Re: Portland Retirement Residence

These are responses to your email comments/redlines dated March 23, 2016.

DATE: 8/28/2015
REVISED DATE: 9/22/2015, 2/2/2016, 4/15/2016
SHEET: A7.1b

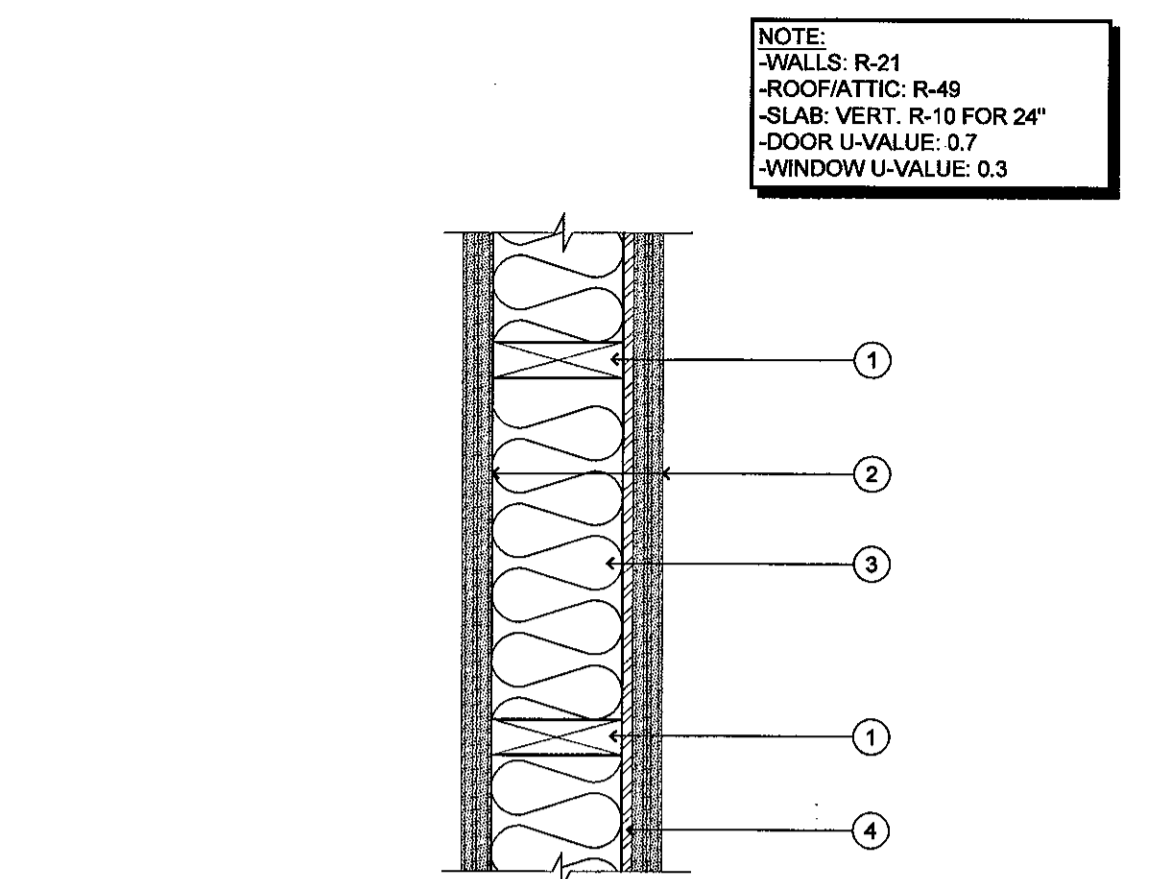
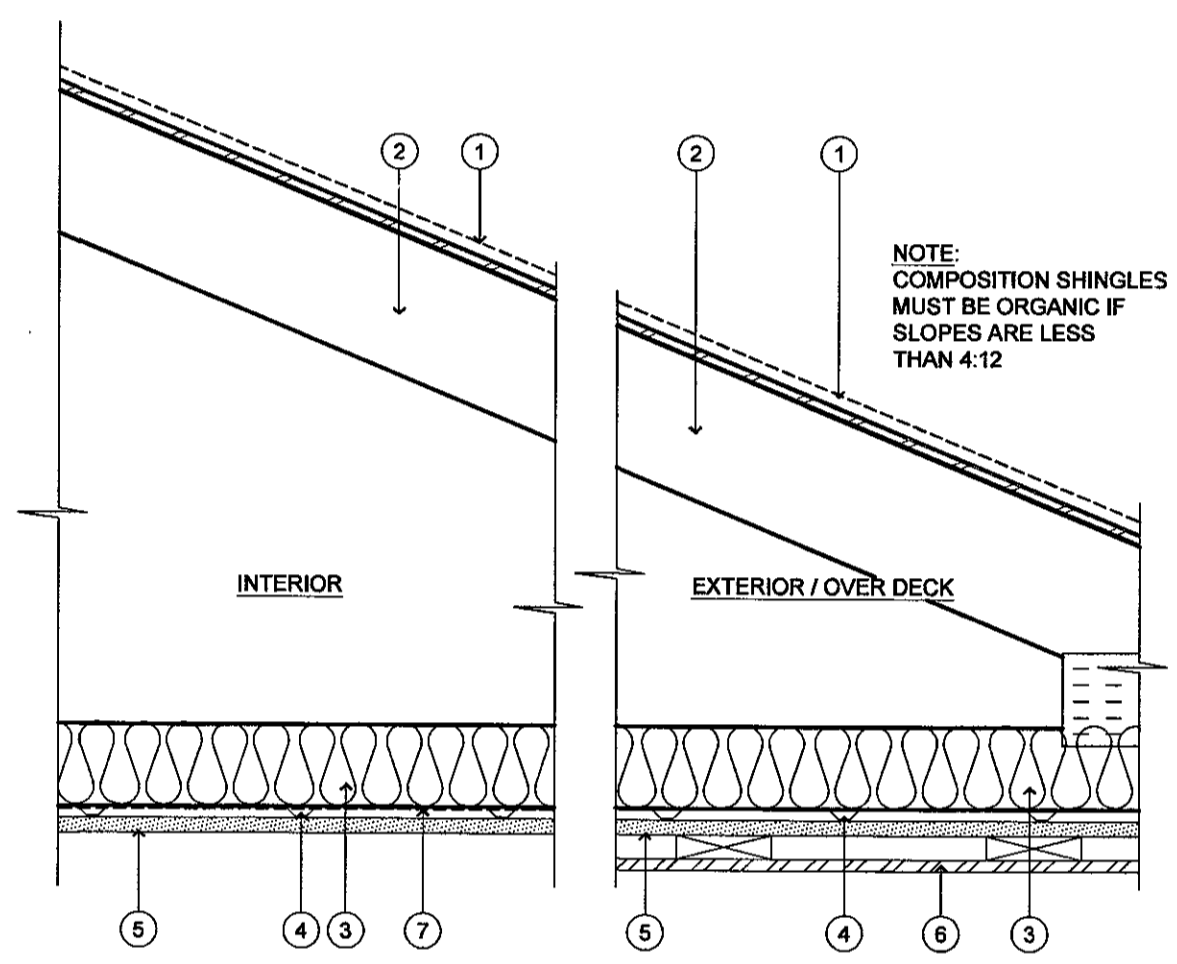
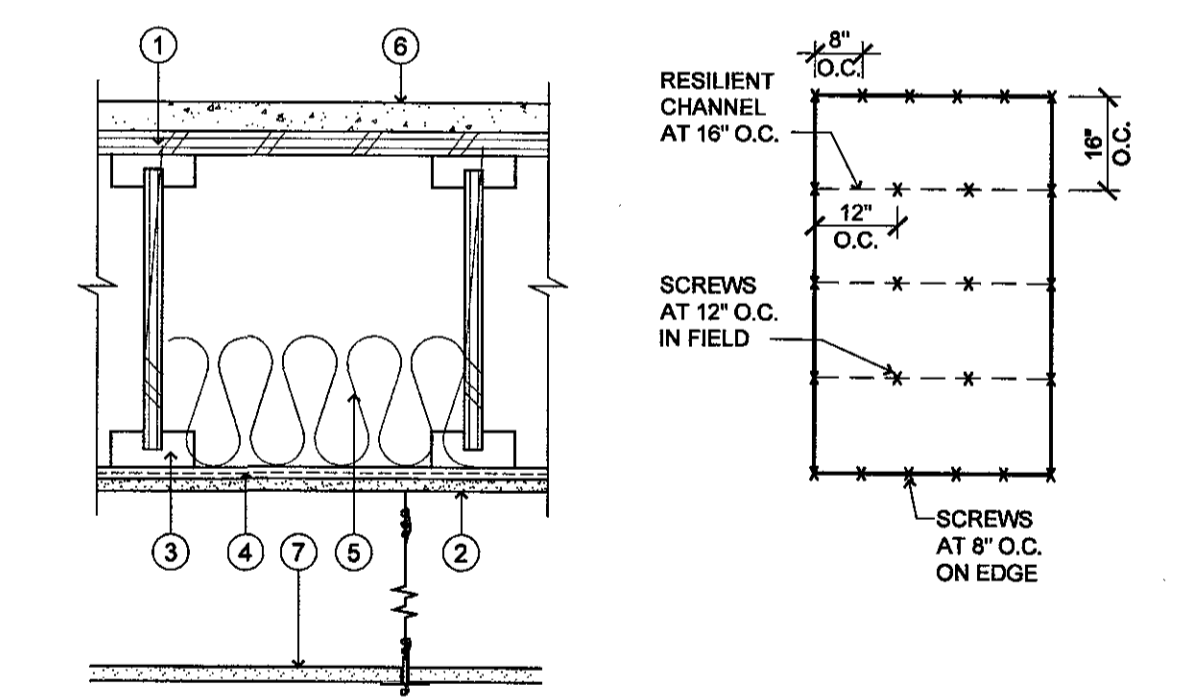
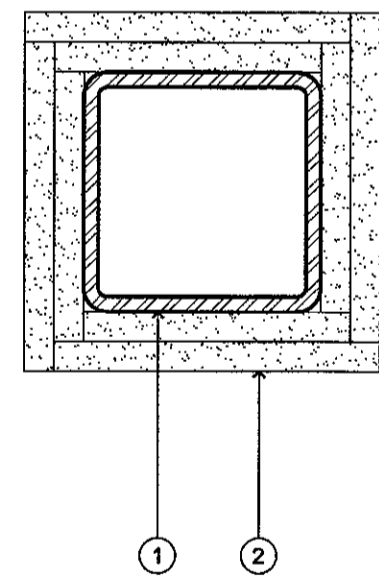
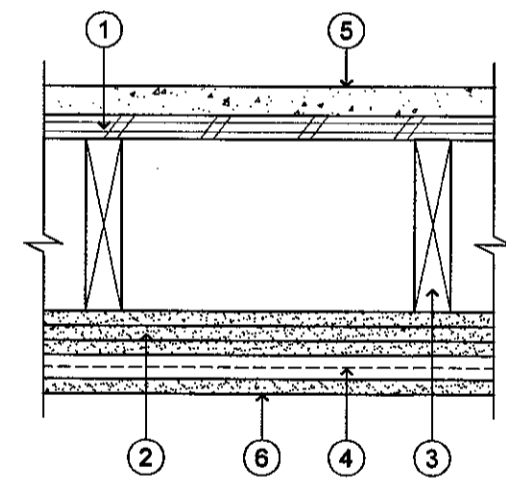
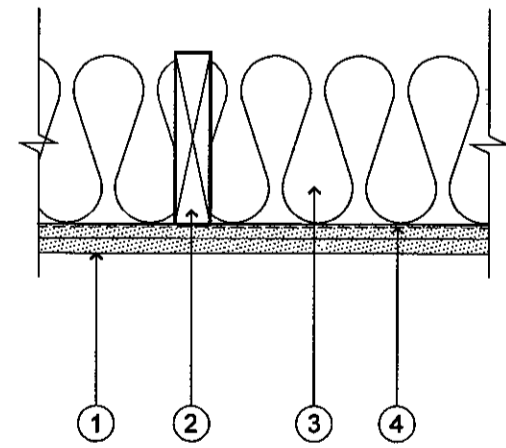
14. Label all floor and wall assemblies. The floor assembly N for the roof deck or J for elevator shaft is not called off. Please revise.

Please note that A7.1b has had the missing assemblies added.
